MEMORANDUM

SUBJECT: Ellicott Town Center
RE: Traffic Impact Study
Response to Comments Memorandum
LSC #194060

Following are the LSC Transportation consultants, Inc. responses to the January 23, 2020 Comment Letter prepared by CDOT – Region 2 – Traffic & Safety – Permits regarding CS192_SF1910_SF1825.

Figure 4  
**2021 Baseline Traffic\*, Lane  
 Geometry, and Traffic Control**  
 Ellicott Town Center Rezone (LSC# 194060)

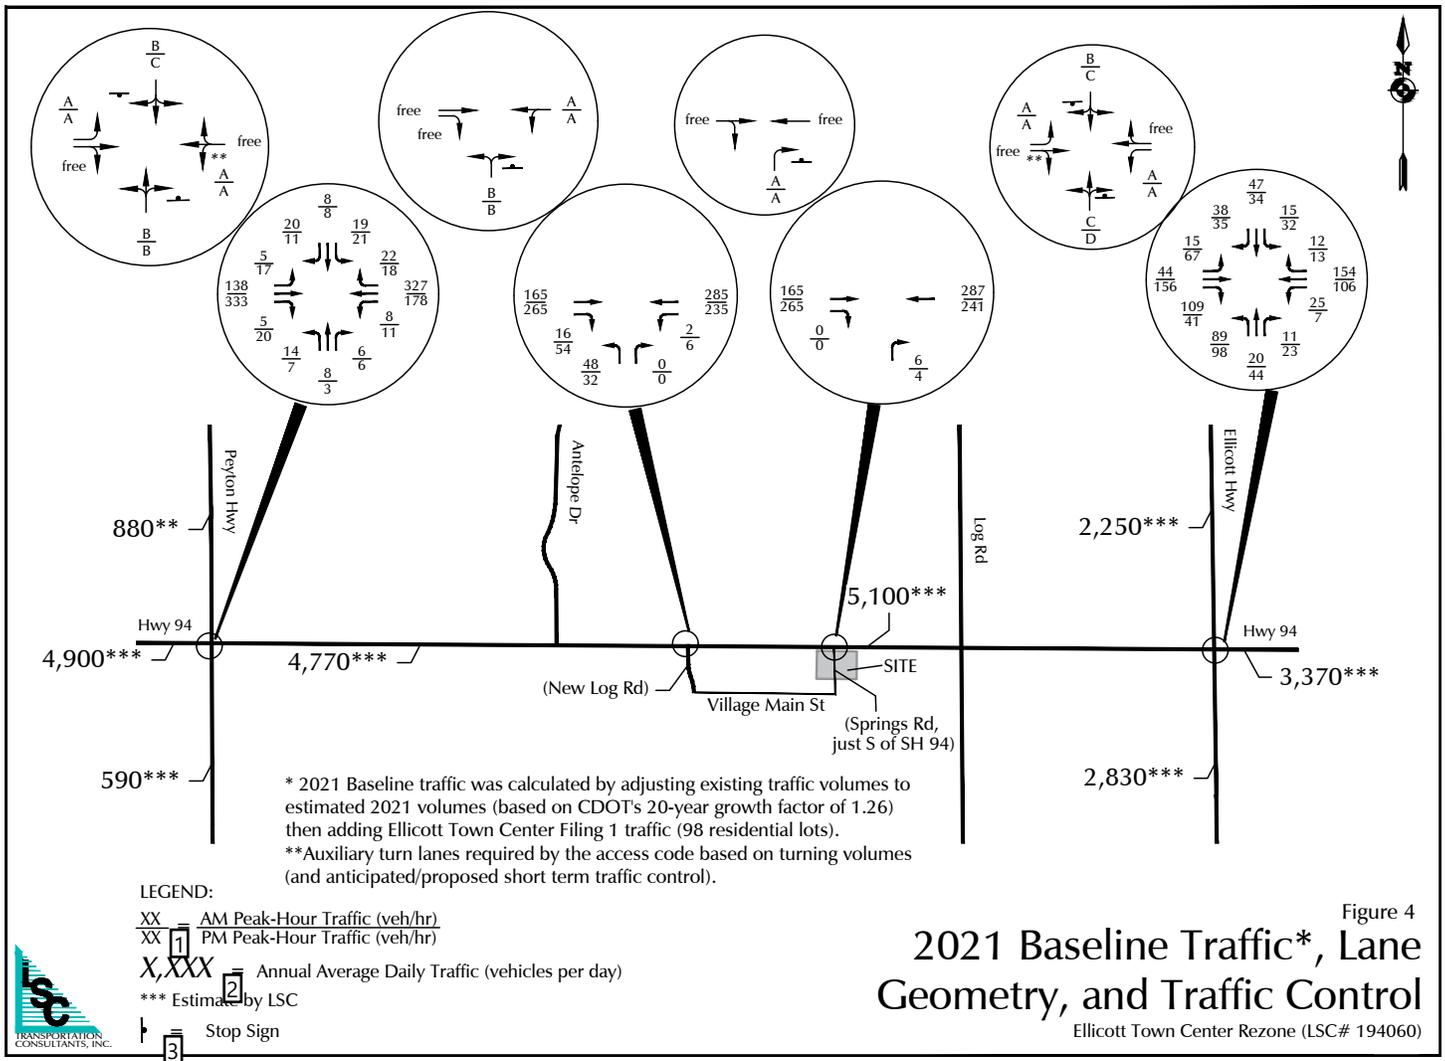
- k. The baseline Synchro reports for Hwy 94 & Peyton Highway intersection has incorrect lane geometry, please adjust.*

LSC Response: These reports have been corrected in the updated report.
